5 November 2018

Application Reference: 6/2018/2386/COND
Proposed development at: 8 Hill Rise, Cuffley, Potters Bar, EN6 4EE
Proposal: Submission of details pursuant to condition 1
(Details of crown roof and cross section drawing) on planning permission
6/2018/0383/FULL

Issue Date	10/09/2018
Revision	
Paper Size	A1
Sheet Number	A115
Sheet Title	Proposed Roof Details 2
Project Address	8 Hill Rise, Potters Bar, EN6 4EE

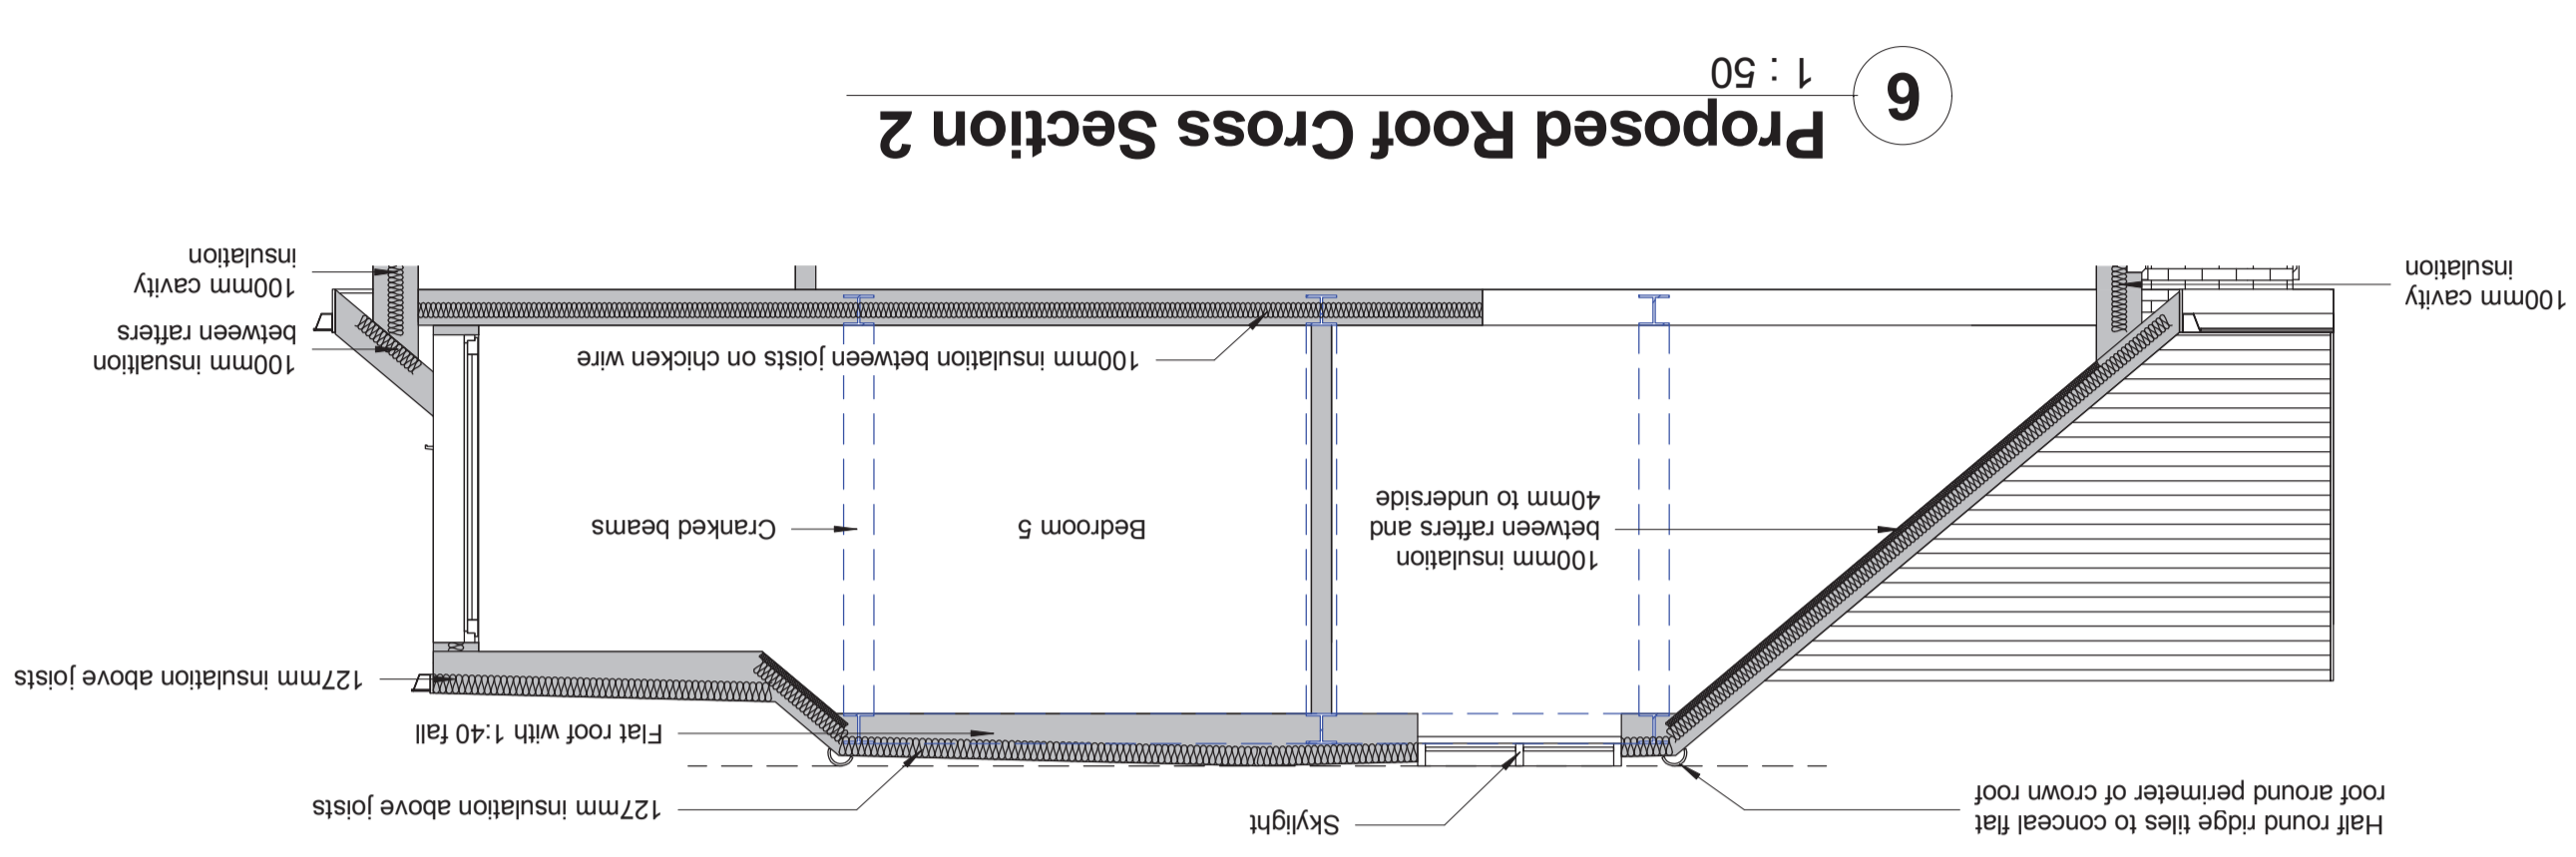
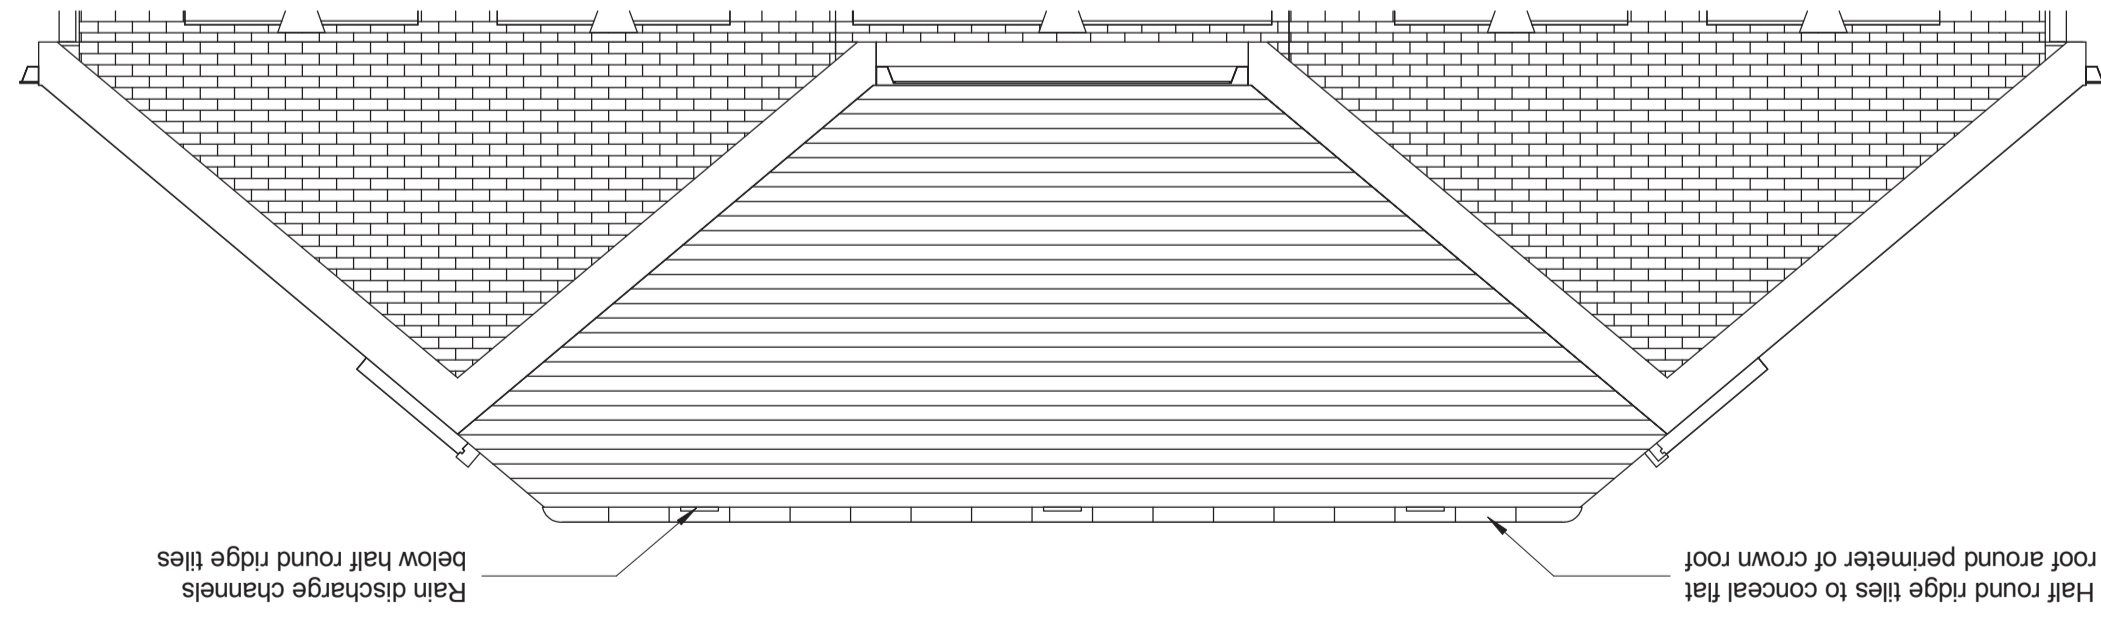
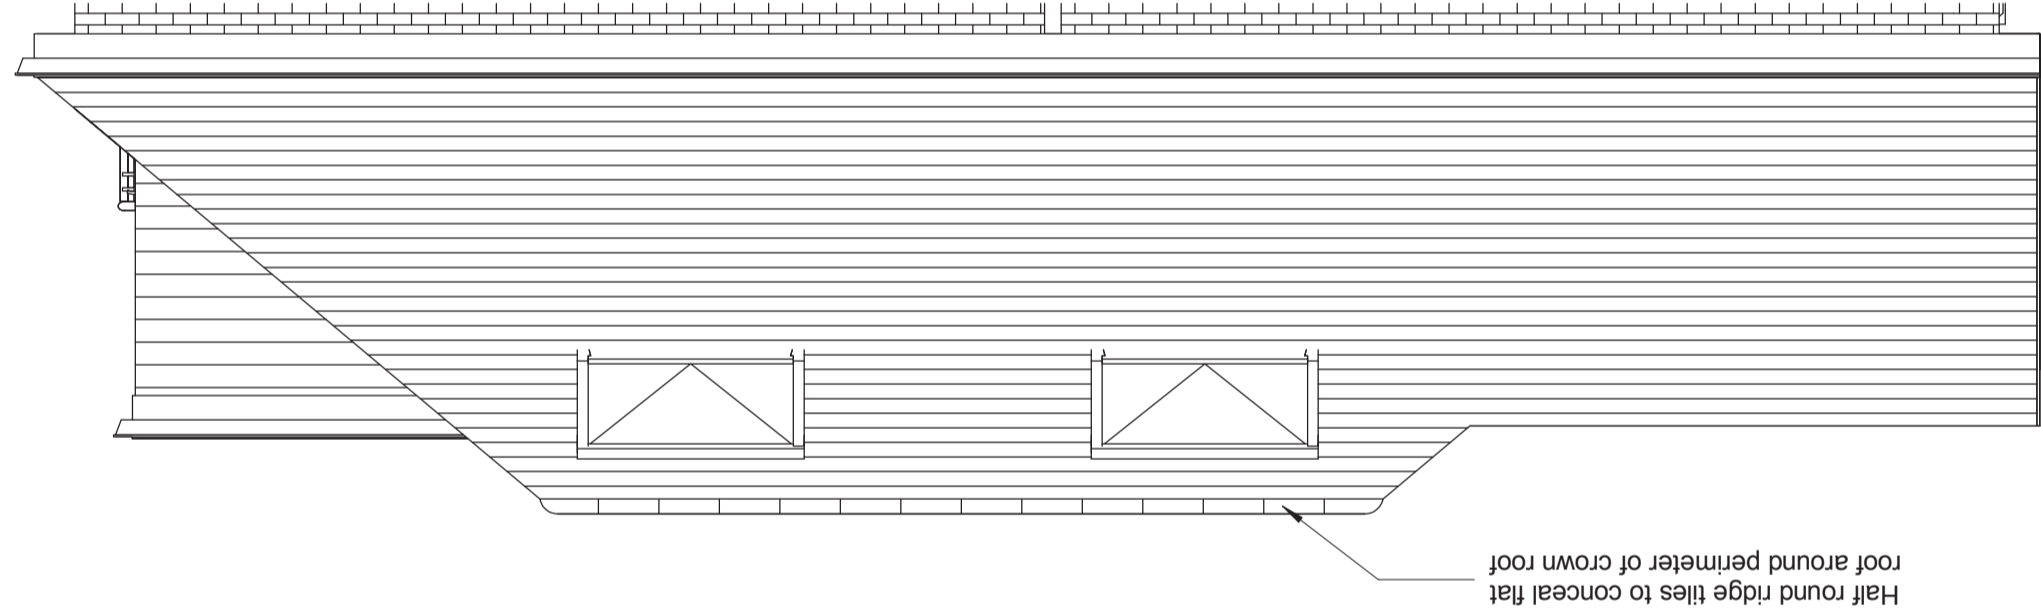
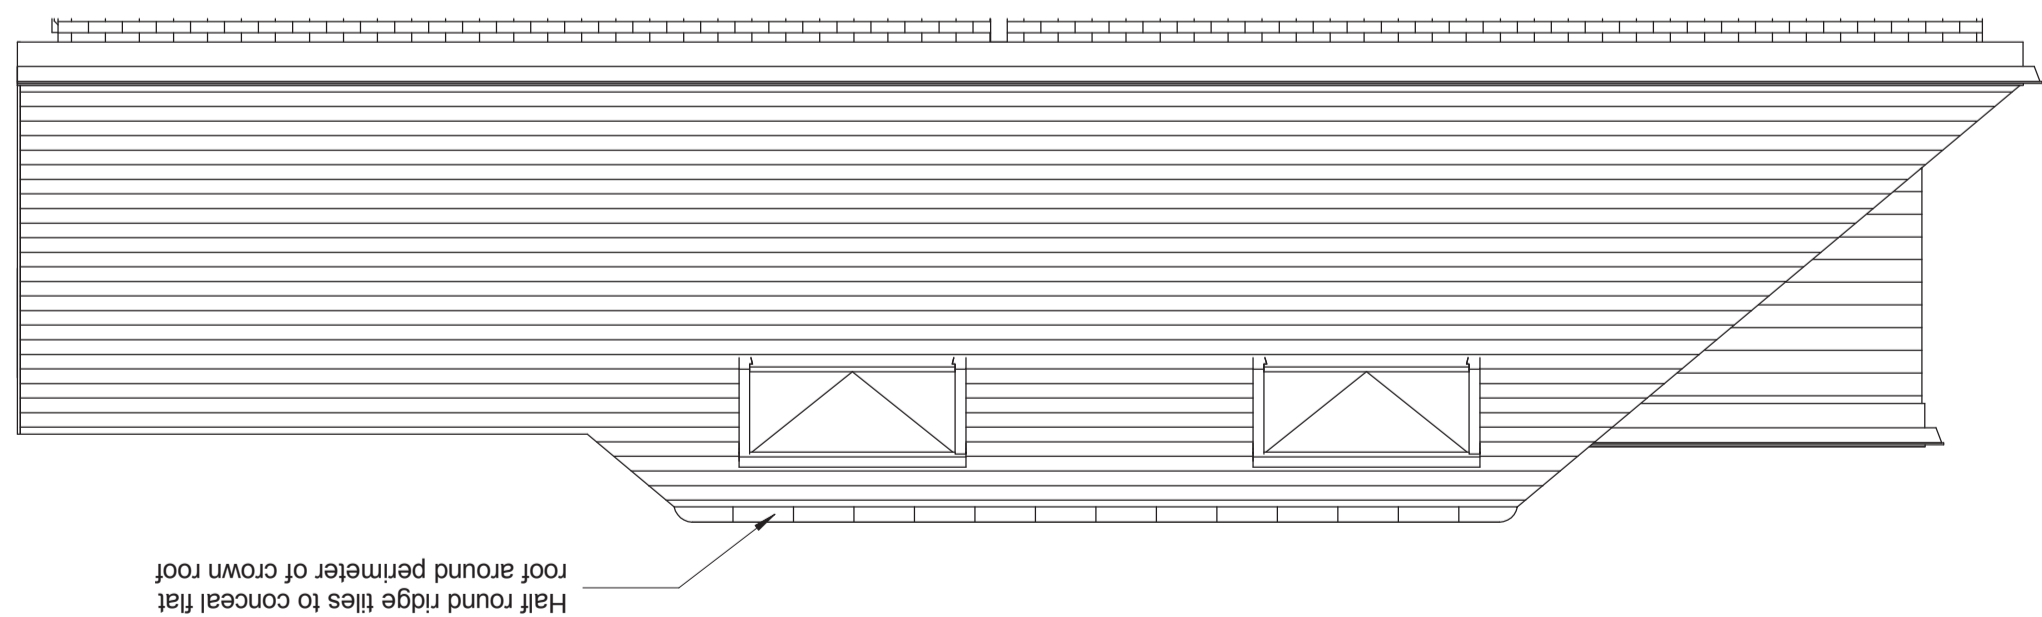
Please note that lead flashing must not be visible on the external roof-slope nor overhang any of the ridge tiles hereby approved.
